Our Ref: EN010117

### **Proposed Application by Rampion Extension Development Limited for an Order Granting Development Consent for the scheme Rampion 2 Offshore Wind Farm – EN010117**

#### **Advice following issue of decision to accept the application for examination**

DRAWING NUMBER: **004927801** PAGE NUMBER: **1 of 6**

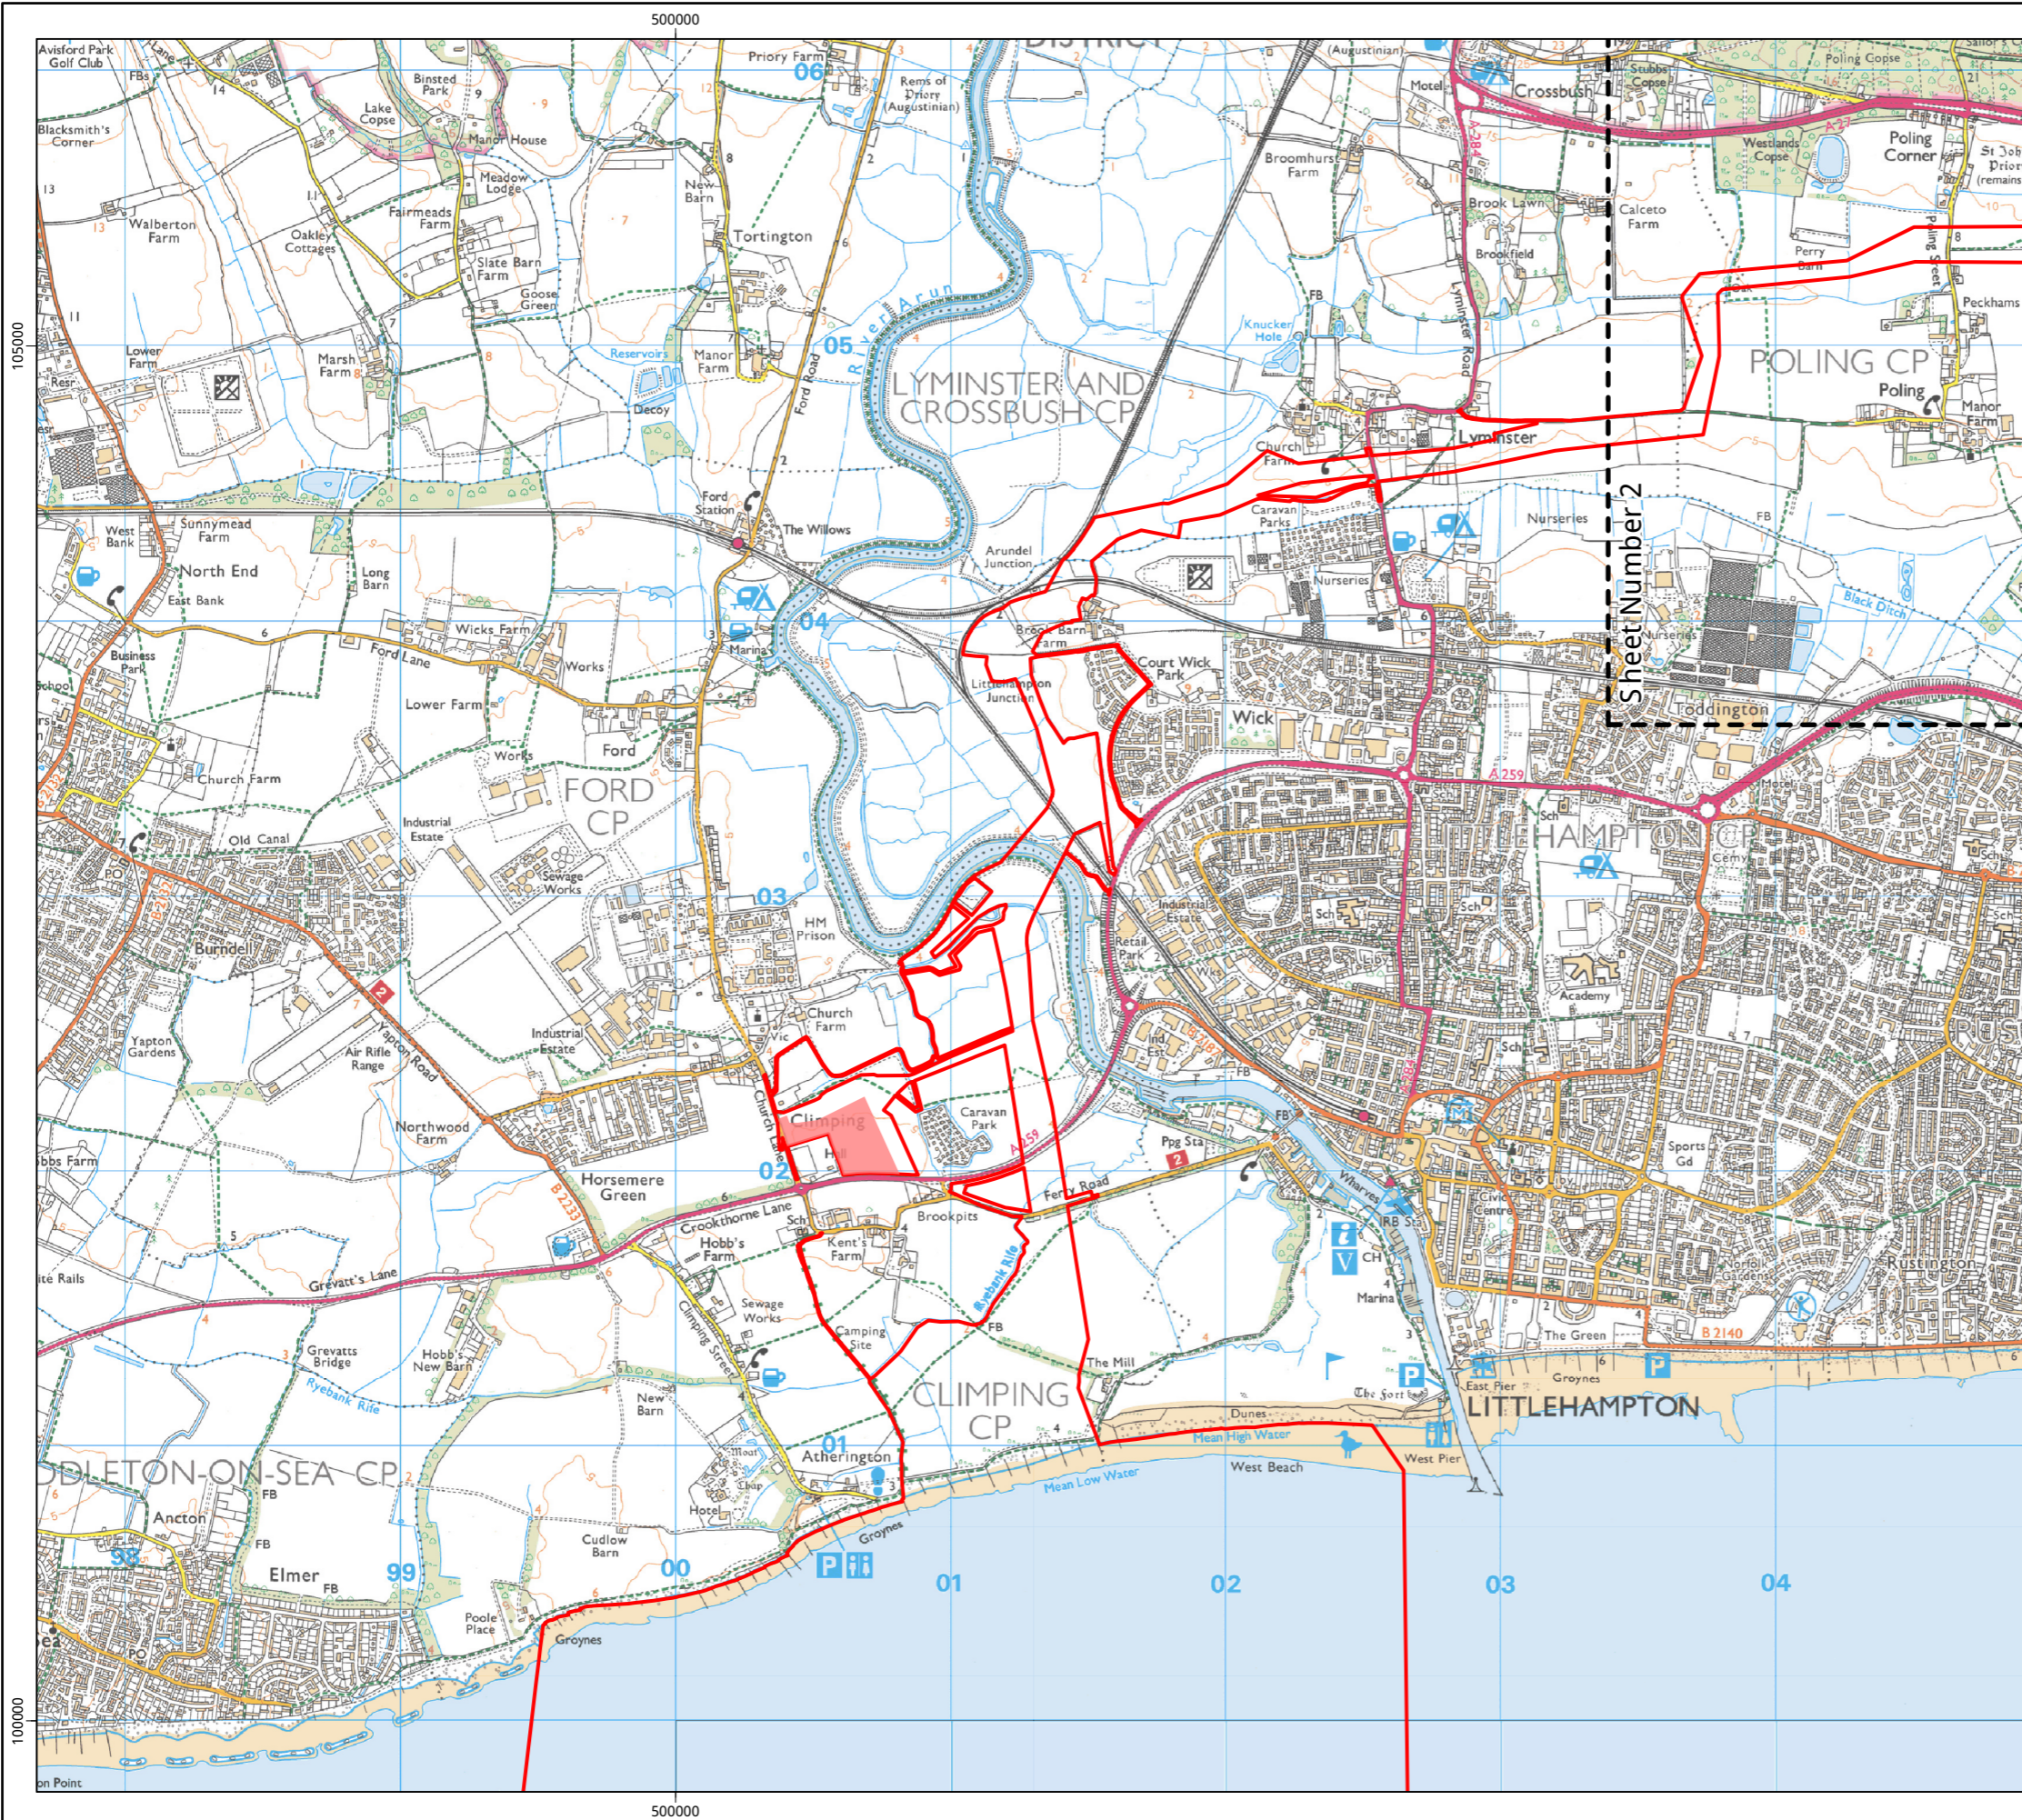
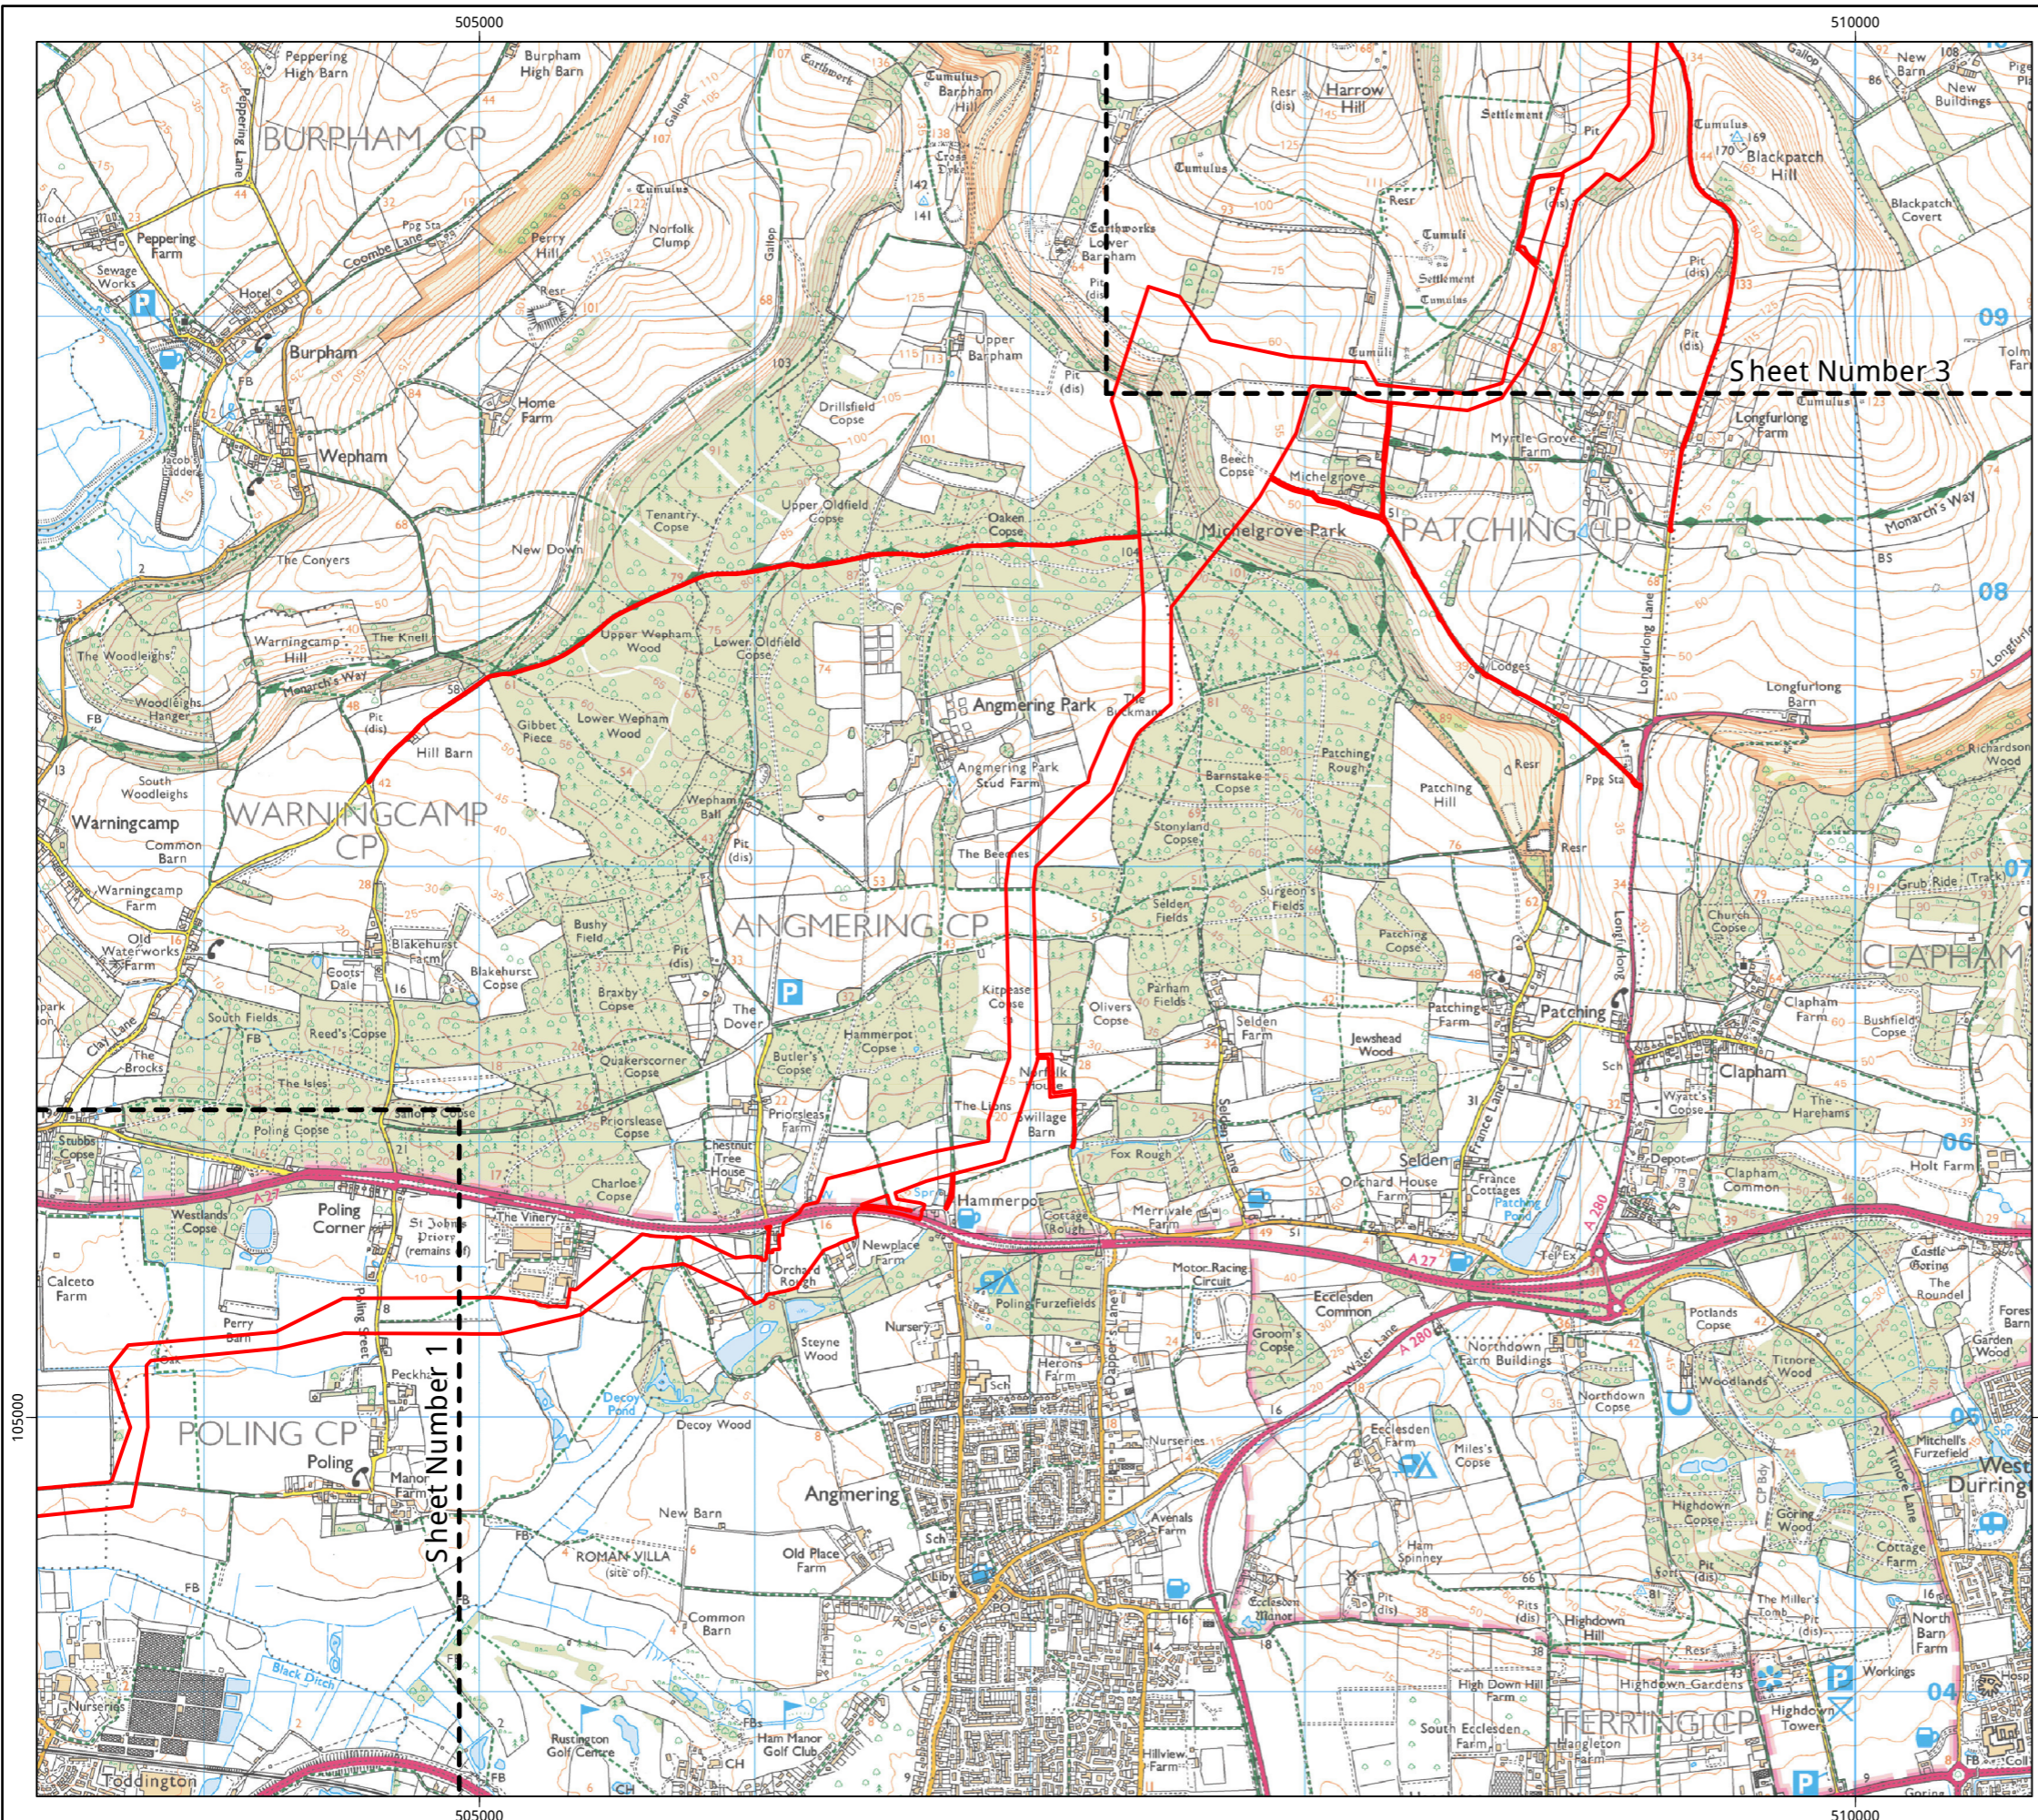
The Inspectorate notes there are no Onshore General Scheme Outline Plans. It is advised that such plans are submitted and that they clearly show arrangements of onshore cable routes.
